Application No: BR/85/21/HH
Site Address: 12 Cavendish Road Bognor Regis PO21 2JW
Description of works: Proposed flat roof balcony and open framed and top glazed veranda unit.

Thank you for your internet representation made on 18th May 2021 which has been recorded as an objection with the comments as follows:

Title
PROPOSED FIRST FLOOR PLAN

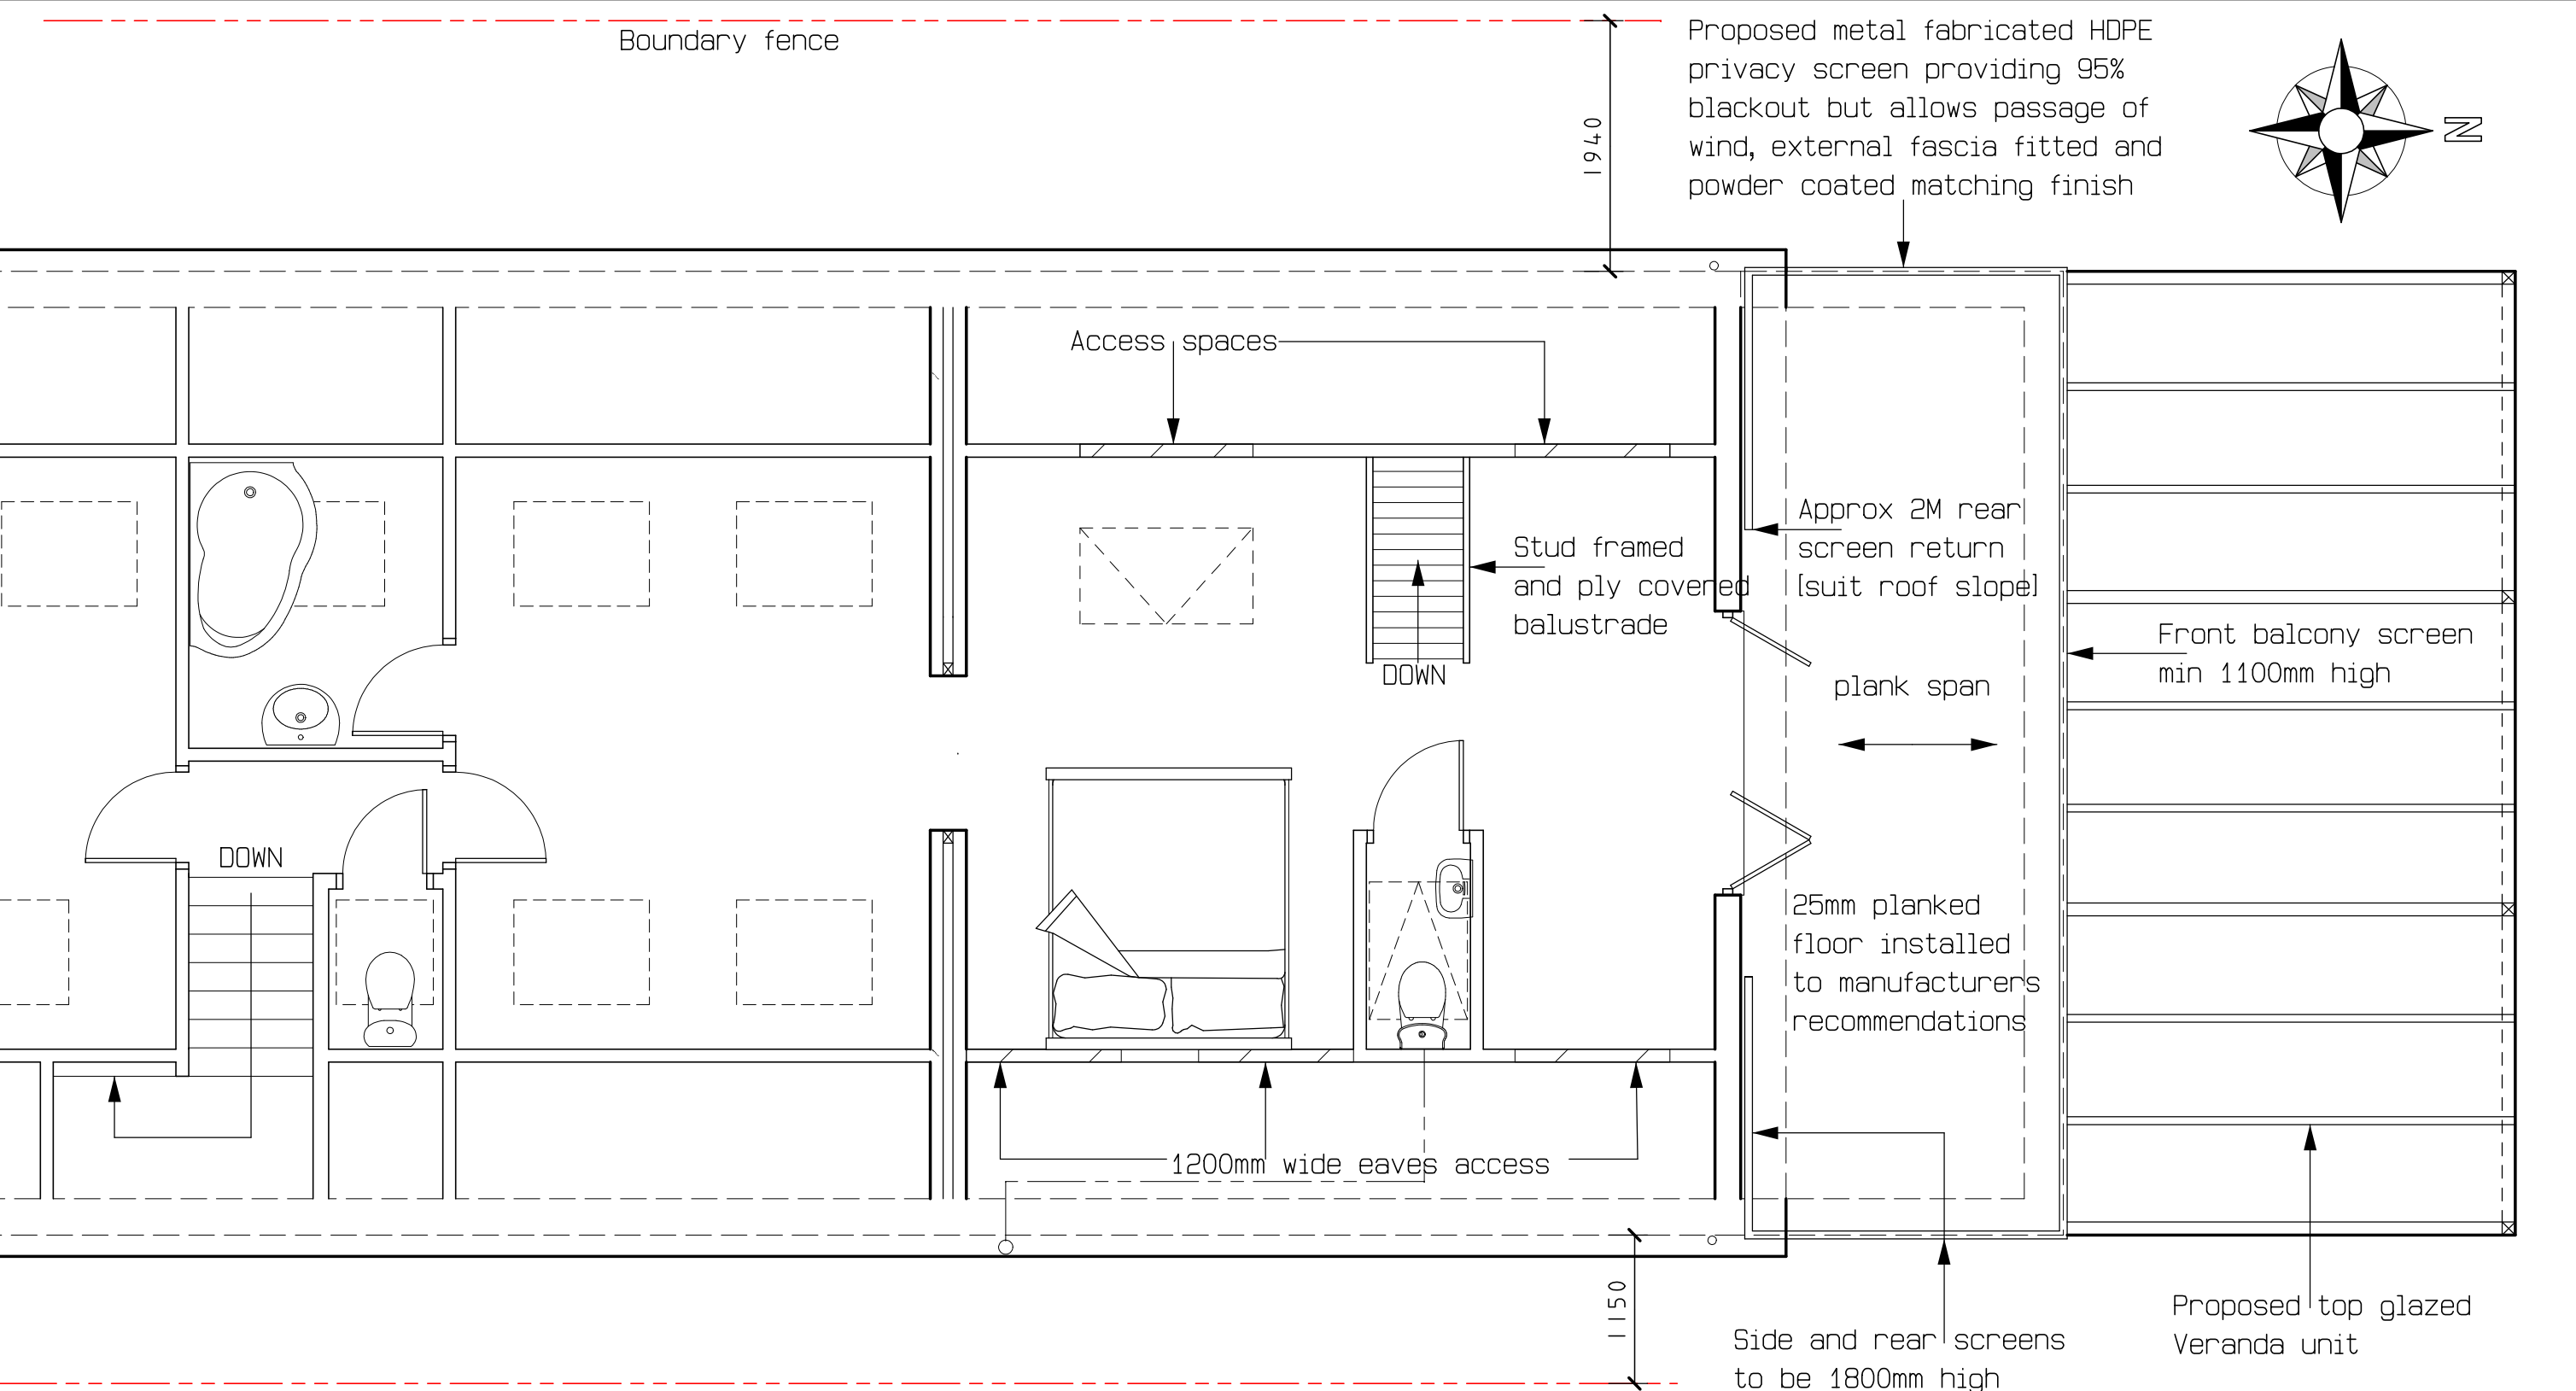
Objection on the material planning grounds that Members consider the proposals to cause overlooking and loss of privacy, thereby having a negative impact on neighbouring properties. Furthermore, Members feel that the design and appearance is out of keeping with the characteristics of the surrounding area.
